Development Control
Ribbles Valley Borough Council

App no: 23.0706

Address: Higher College Farm Lower Road Longridge

Proposal: Proposed erection of 40 Class E(g) units and one battery storage and maintenance unit with associated parking and access. Resubmission of application 3/2022/0553.

Proposed Access Drawing

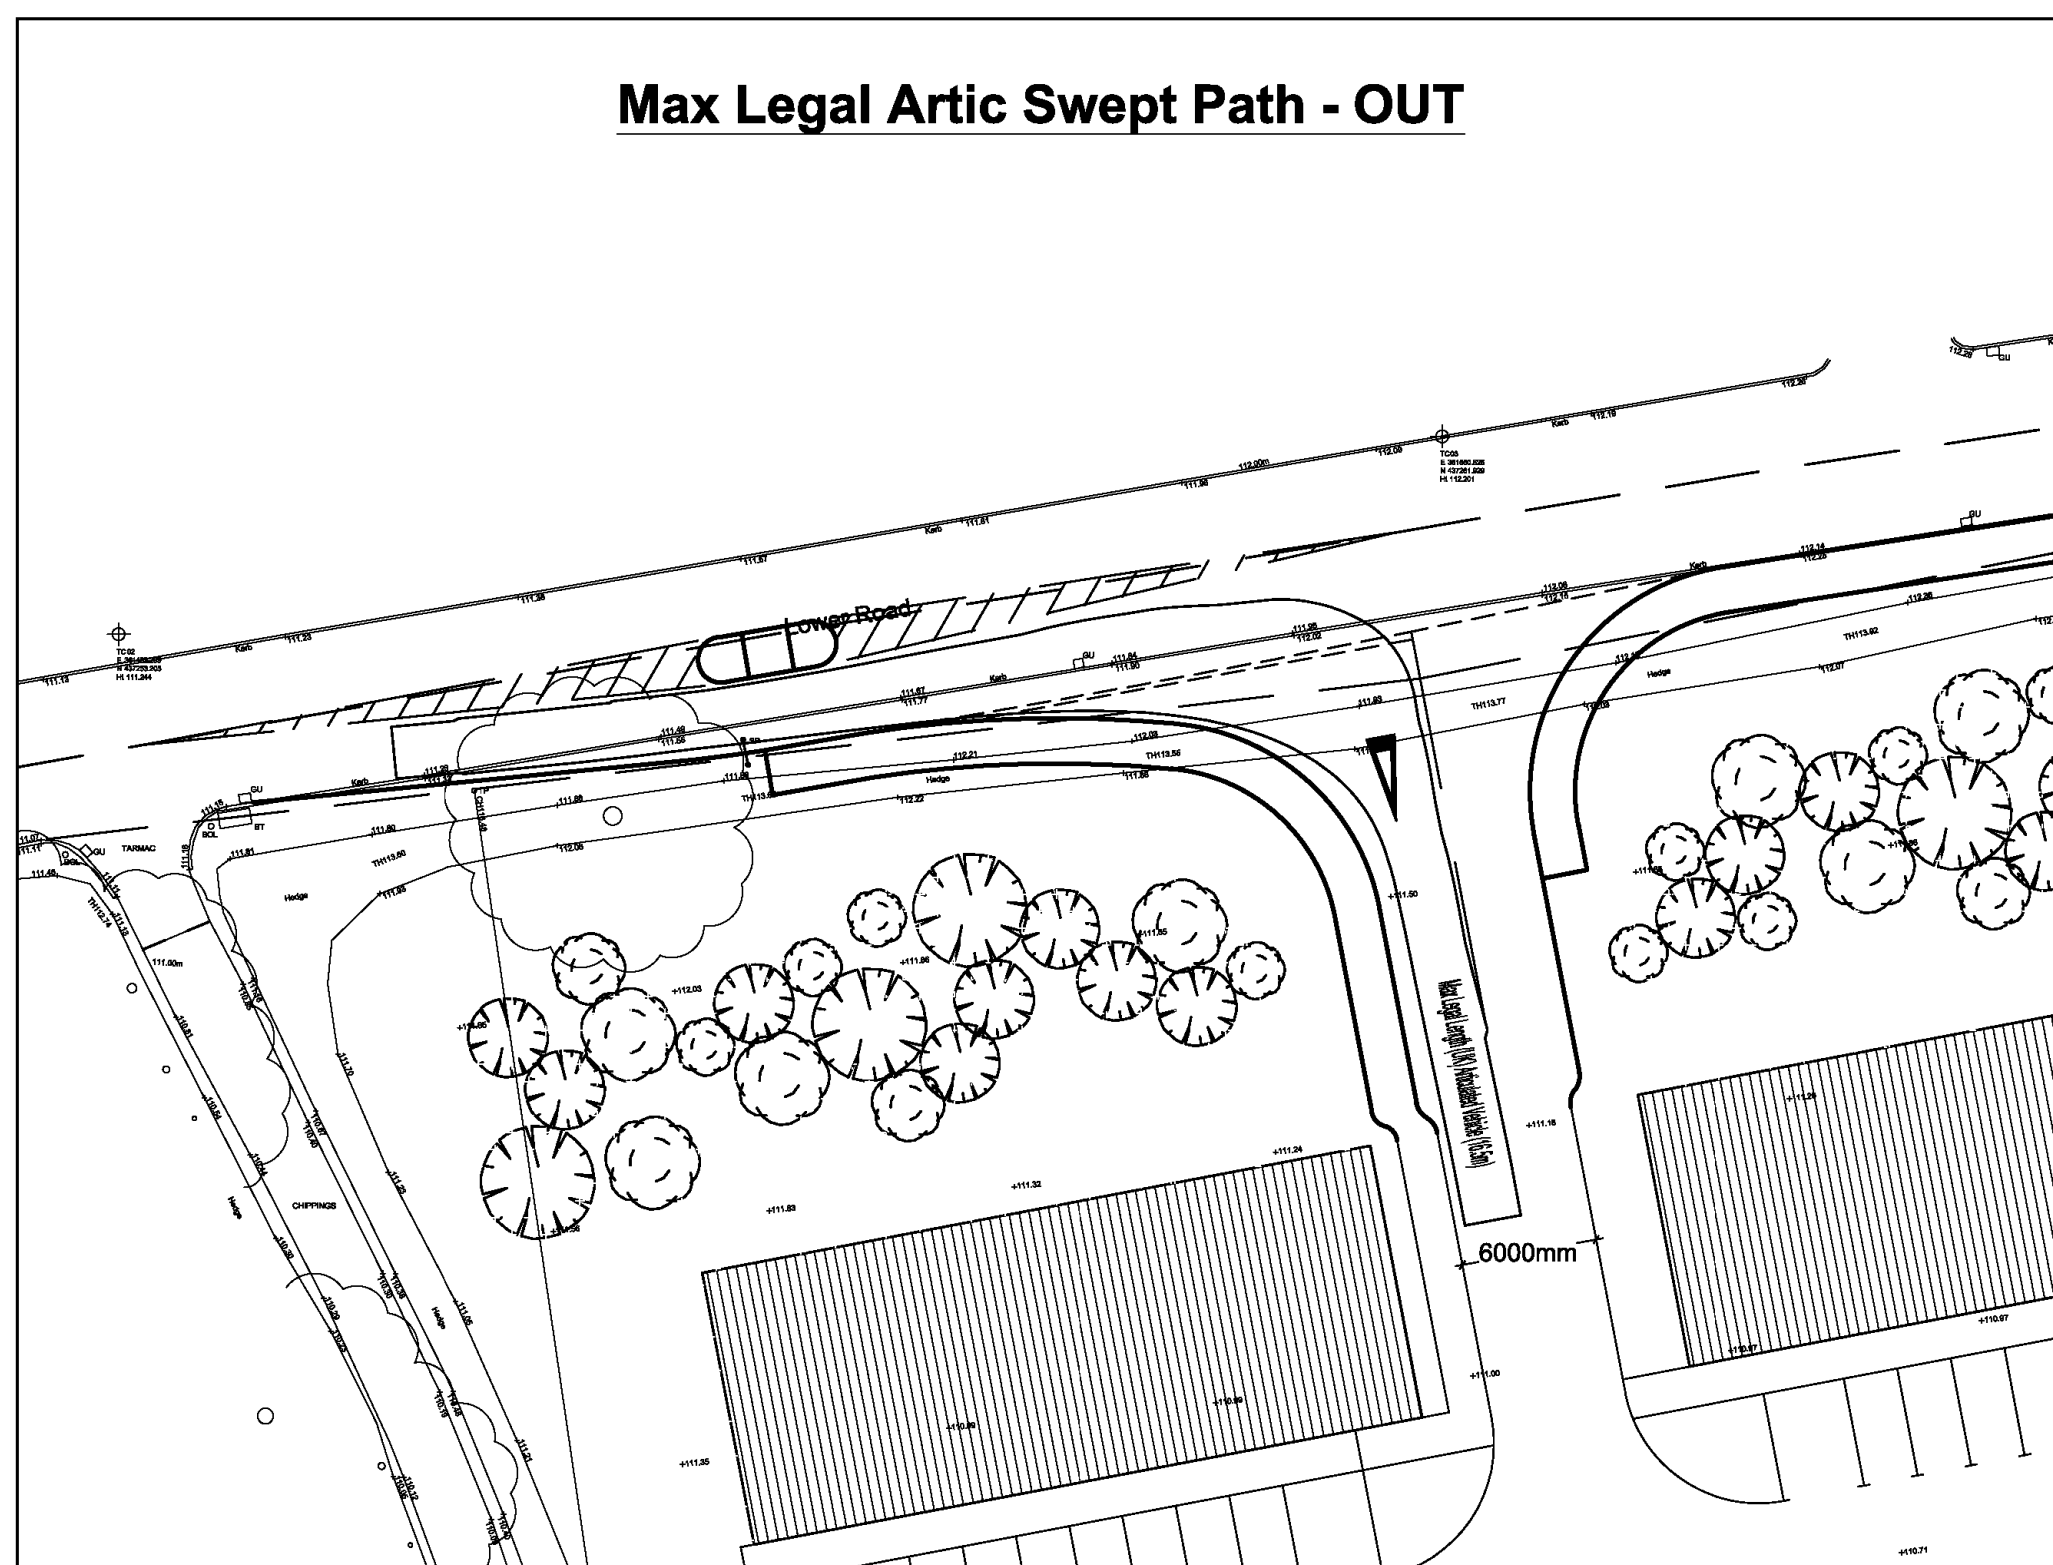
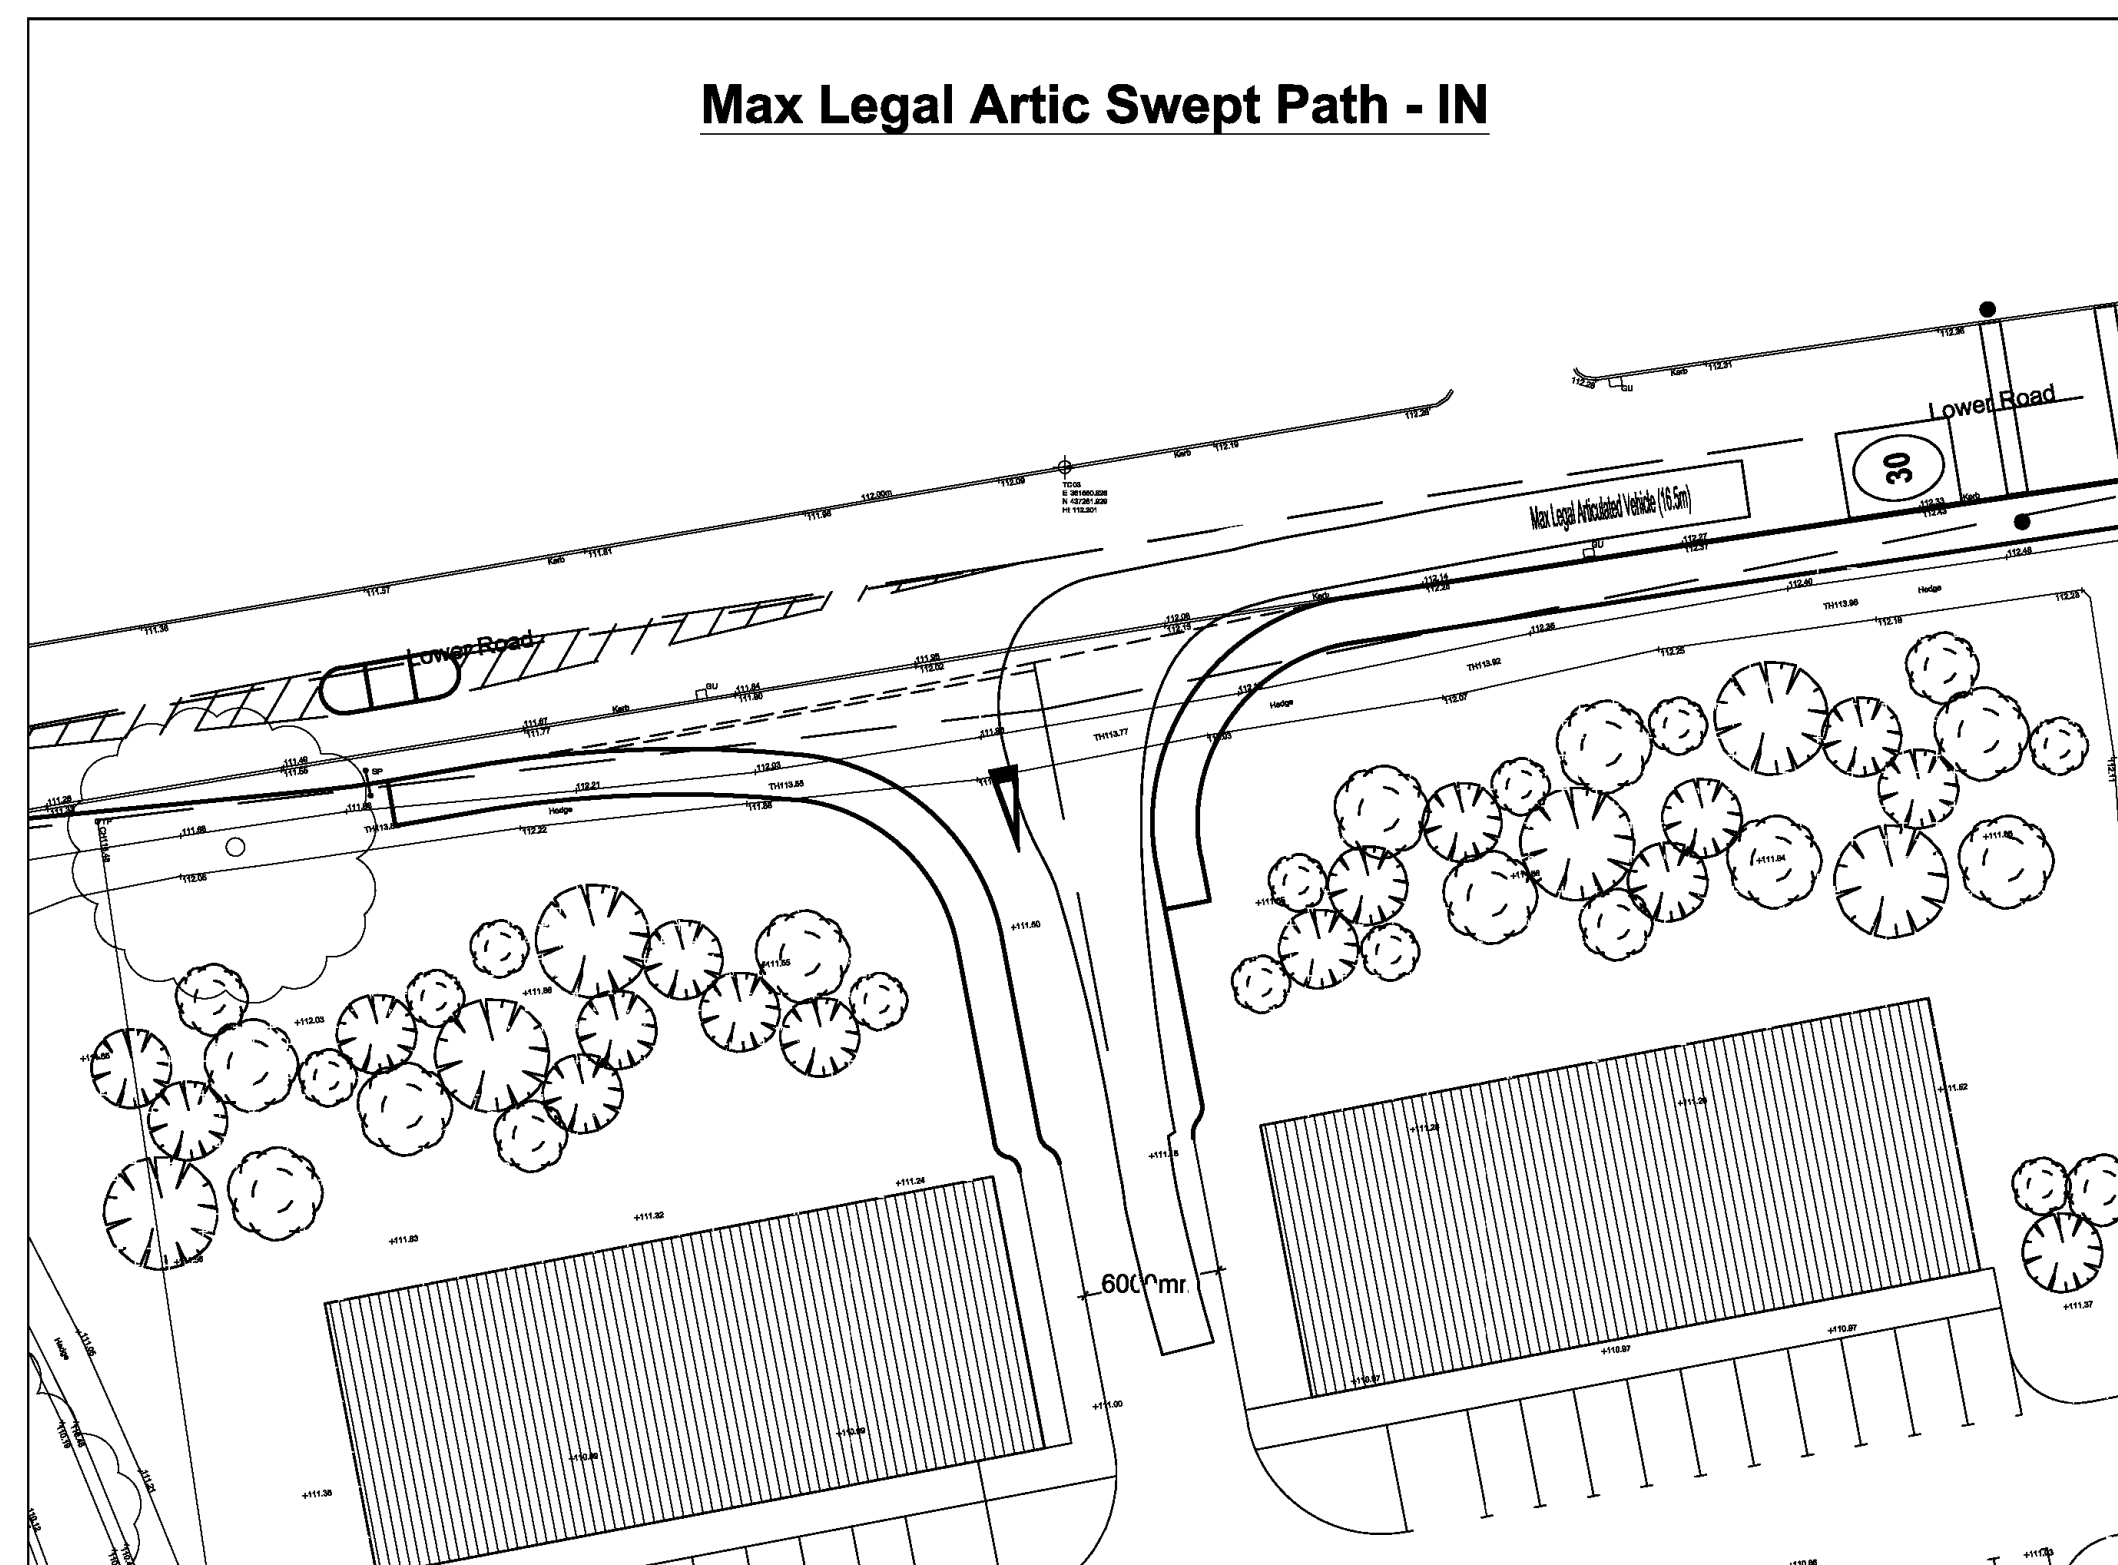
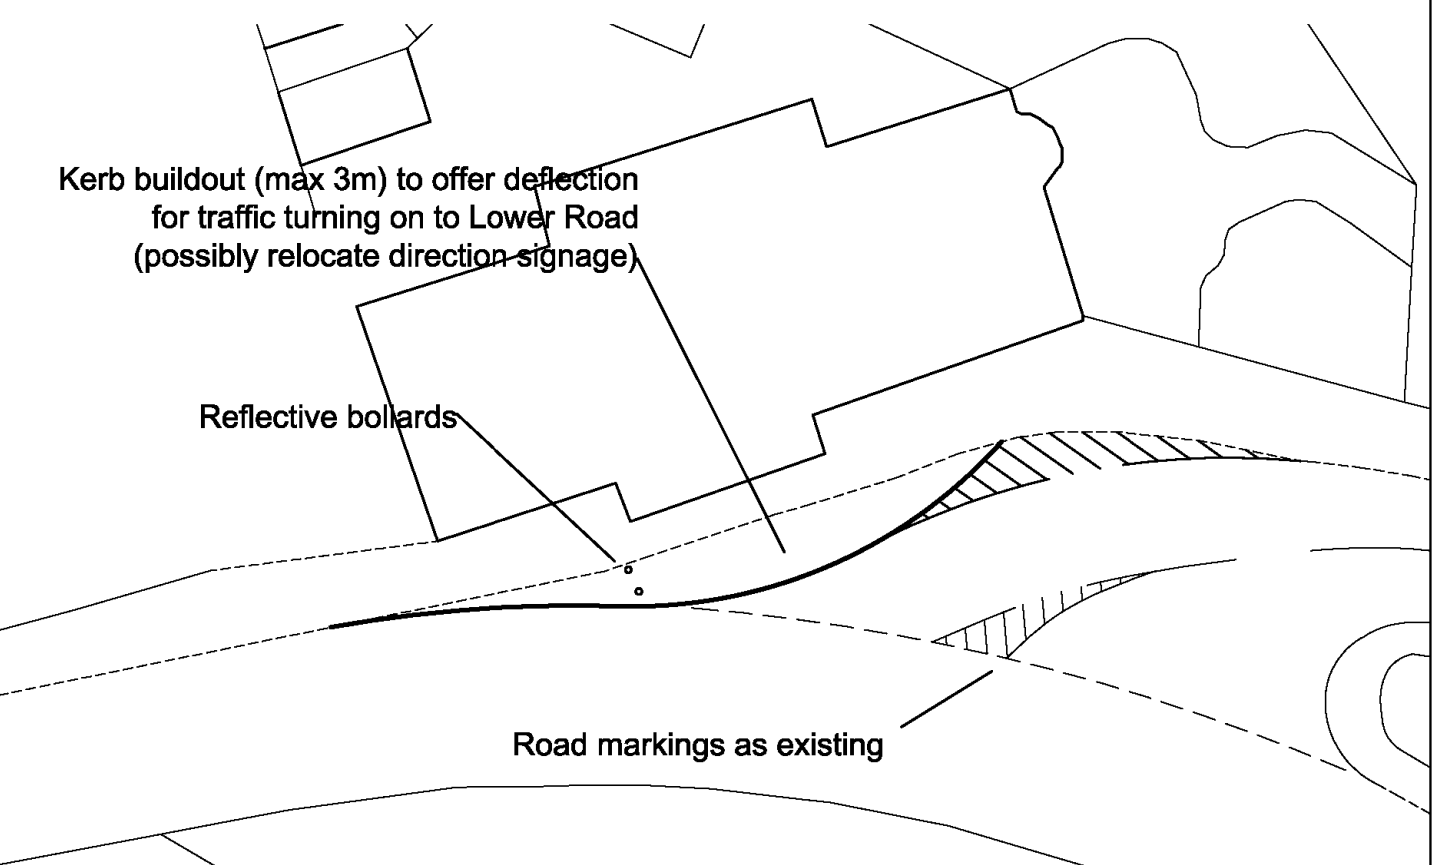
The previously approved drawing PSA Design H2683-01 Rev A dated Nov 2017 is submitted for this application and the design is carried forward onto 'Evolve Architectural Design Ltd 'Proposed site plan' EAD_203_03_Rev C2' and is deemed suitable to accommodate the development traffic.

The new access will serve the whole development and will need to be constructed prior to the works commencing on site.

The existing access on Lower Lane will remain open to serve the existing farmhouse and field accesses. The existing gap in the hedge will be infilled to separate the existing access from the development site. We do not support the intensification of use of the existing access due to sub standard geometry and visibility splays.
